**From:** Tom Errico <thomas.errico@tylin.com>  
**To:** Helen Donaldson <HCD@portlandmaine.gov>  
**CC:** "Margolis-Pineo, David" <DMP@portlandmaine.gov>, Katherine Earley <KAS@portlandmaine.gov>, Jeremiah Bartlett <JBartlett@portlandmaine.gov>, Jeff Tarling <JST@portlandmaine.gov>  
**Date:** 3/18/2015 4:48 PM  
**Subject:** 1210 Brighton Avenue - Final Traffic Comments

Nell - The following is a status update of my prior comments and represents my final comments. I find the project to be acceptable with the following detailed comments.

Sheet Title:
PAVEMENT MARKING AND SIGNAGE PLAN

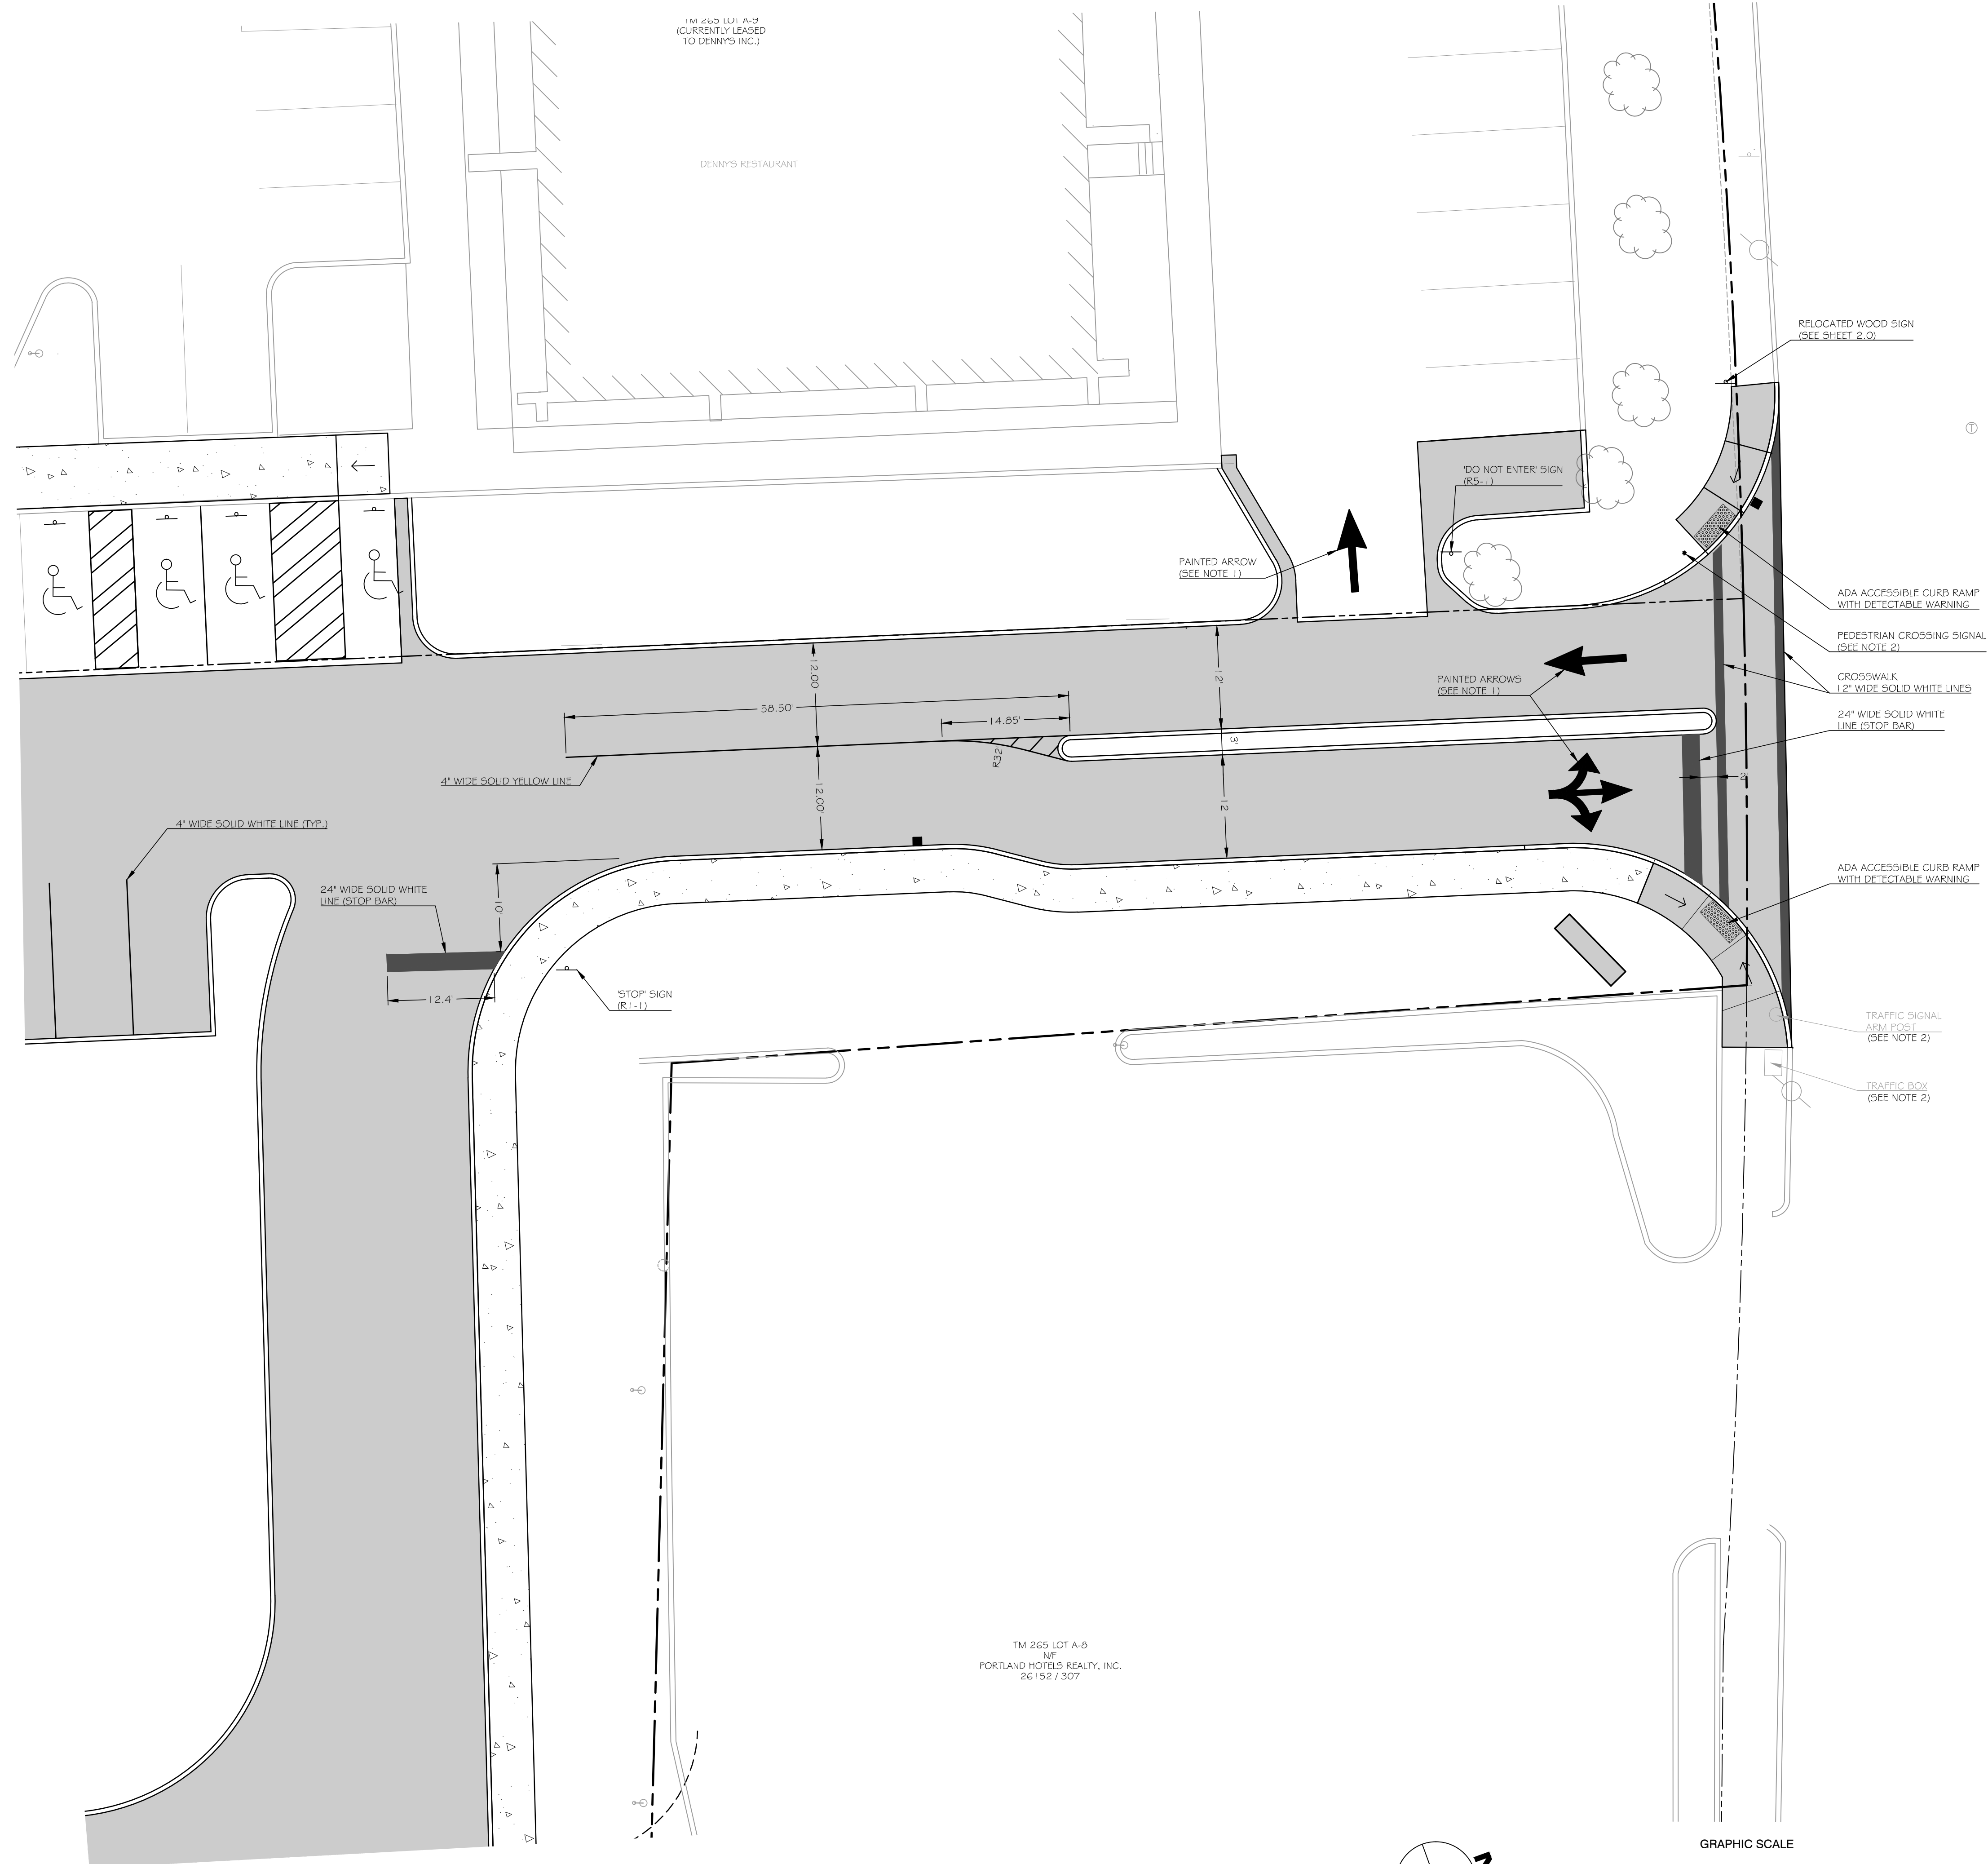
New Comment: The applicant should provide details on pavement markings (STOP Bar and lane line for traffic delineation purposes) at the intersection of the Hotel Drive and the main driveway from Brighton Avenue. This can be a condition of approval.
